Application Ref:	3/2025/0985			 Ribble Valley Borough Council www.ribblevalley.gov.uk
Date Inspected:	08/01/26	Site Notice:	N/A	
Officer:	LW			
DELEGATED ITEM FILE REPORT:				APPROVAL

Development Description:	Proposed demolition of existing single storey rear extension and erection of two storey side extension and single storey rear extension and creation of additional parking spaces.
Site Address/Location:	1 Moorend, Clitheroe, BB7 1JZ.

Robinson Barn Weston Clitheroe Lancs BB71GA		 Architects Registration Board	
Client	MR H LINGARD	Scale	1:100
Project	1 MOOREND CLITHEROE	Drawing Title	PROPOSED ELEVATIONS
		Drawing Status	PLANNING
Job Number	25-066	Drawn By	AW
Drawing Number	PL07	Revision	-
		Checked	AW

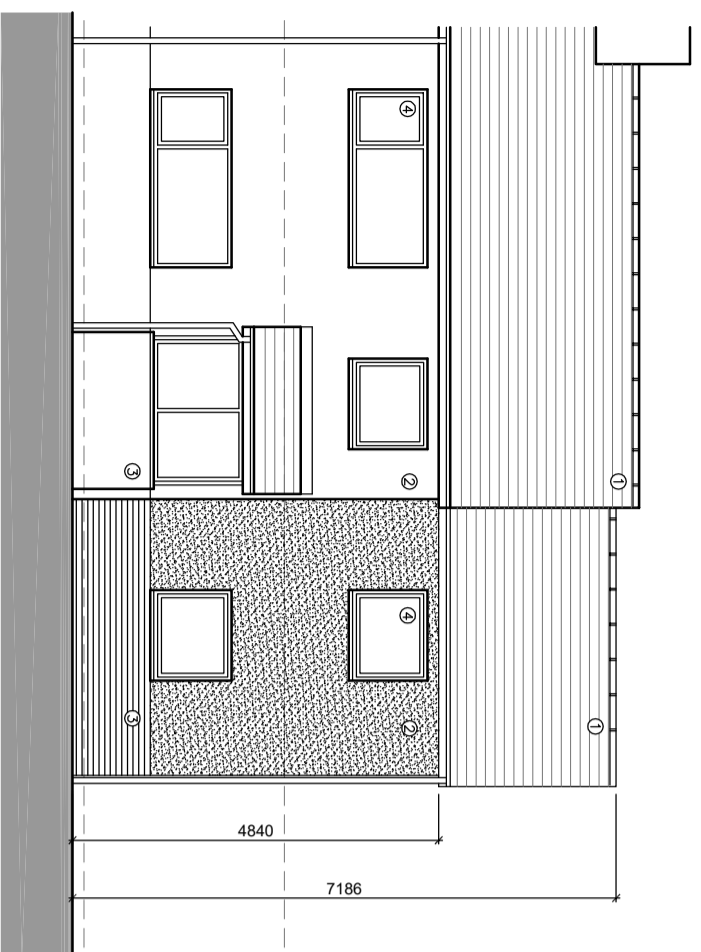
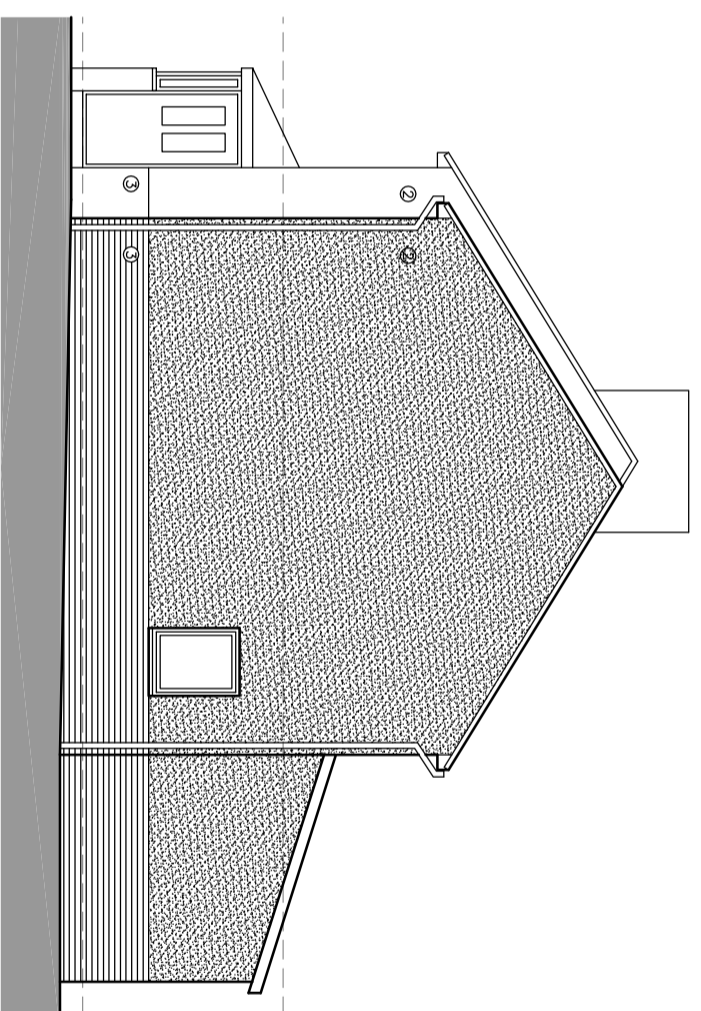
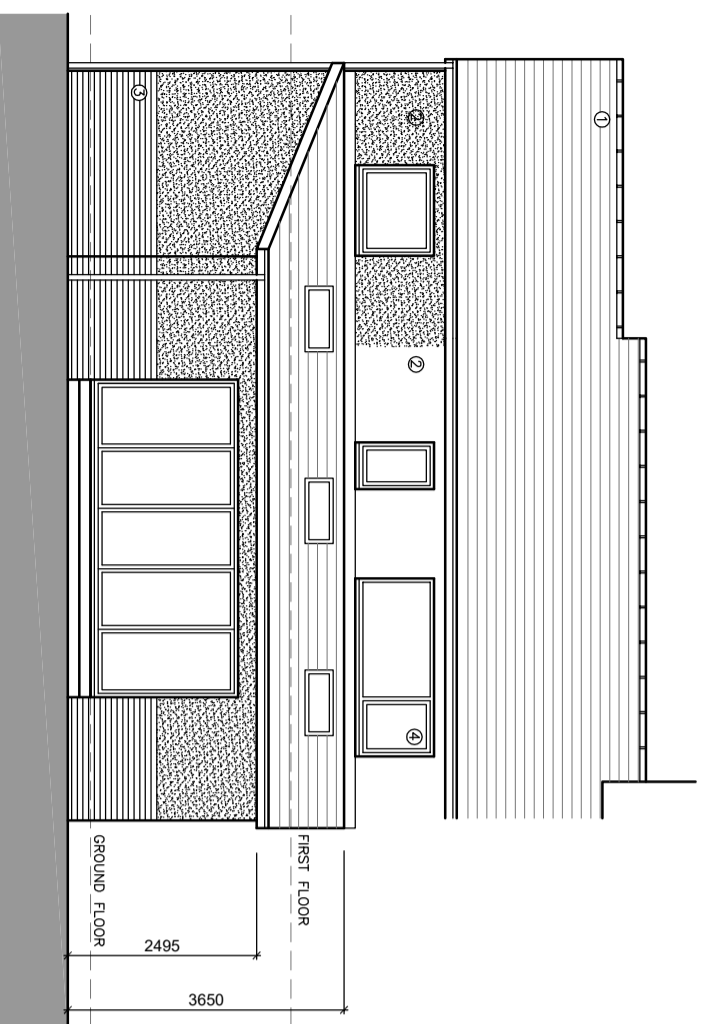
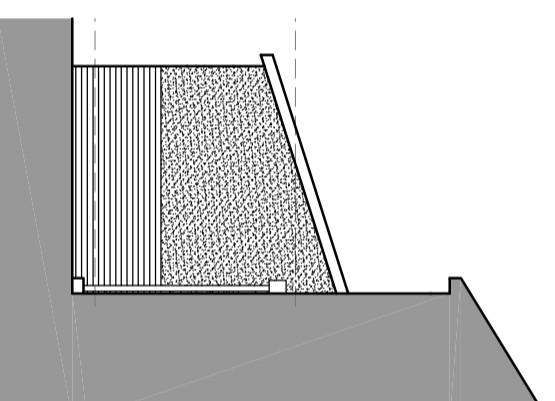
The proposed two-storey extension would project 3.7m from the north-eastern gable elevation of the application property with a depth of 7.1m. A pitched roof form would be incorporated measuring 4.8m to the eaves and 7.2m to the ridge. To the front elevation 1no. window would be featured at both ground and first floor, whilst a personnel door and 1no. first floor window would be included to the side and rear elevation respectively.

The proposed single storey extension would project 3m from the rear elevation of the main dwellinghouse and would extend the full width of the property. A lean-to roof form with an eaves and ridge height of 2.5m and 3.7m would be featured and bi-fold doors would be included to the rear, along with 3no. rooflights.

The application property occupies a visually prominent position within the street scene and therefore the proposed development would have a clear visual impact. Notwithstanding this, the proposed two-storey extension would be adequately set back from the principal elevation of the dwellinghouse and set down from the main ridgeline so as to ensure that extension reads as a subservient addition to the primary building. The degree of projection to the side would also not be significant, insofar that the extension would have a width which is narrower than the existing two-storey dwellinghouse. In this respect, it is not considered that the proposed development would appear an overtly dominant or incongruous addition to the application property or surrounding area in this particular instance.

Furthermore, the development would be finished in materials to match the external appearance of the existing dwellinghouse, including rendered walls with a brick plinth, concreted roof tiles and uPVC framed openings, ensuring visual integration and further reducing the impact of development.

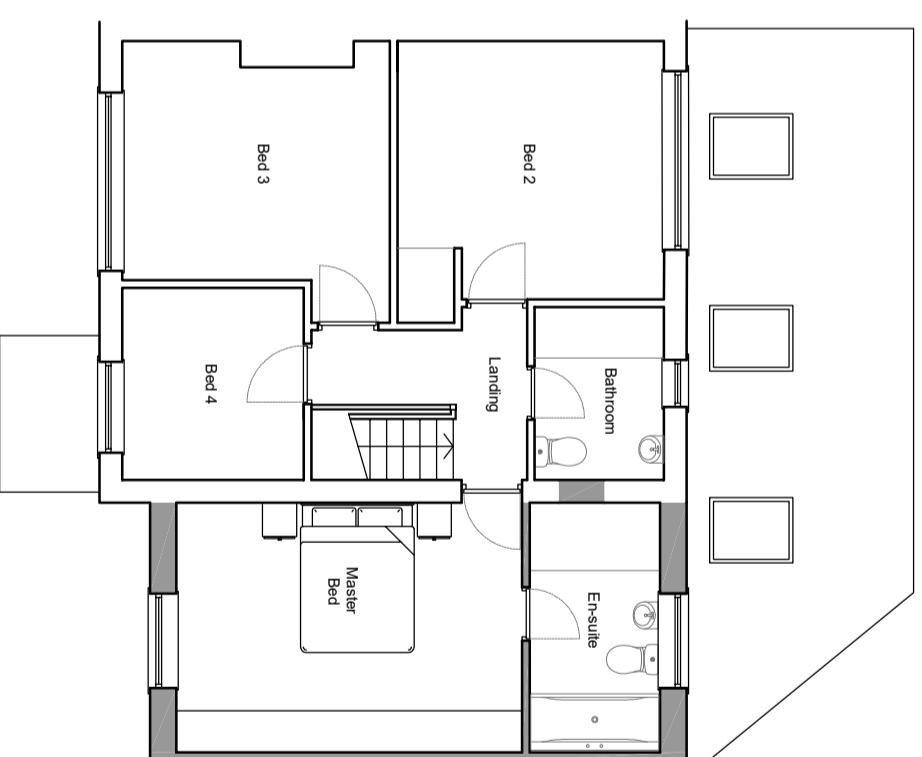
The proposal has been subject to review by Lancashire County Council Highways who raise no objection to the development subject to the imposition of a condition with respect to materiality. The submitted Proposed Site Plan shows that three on-site parking spaces can be accommodated within the site which satisfies parking standards for a four-bedroom dwelling. As such, the proposal is considered acceptable with respect to highway safety and parking.
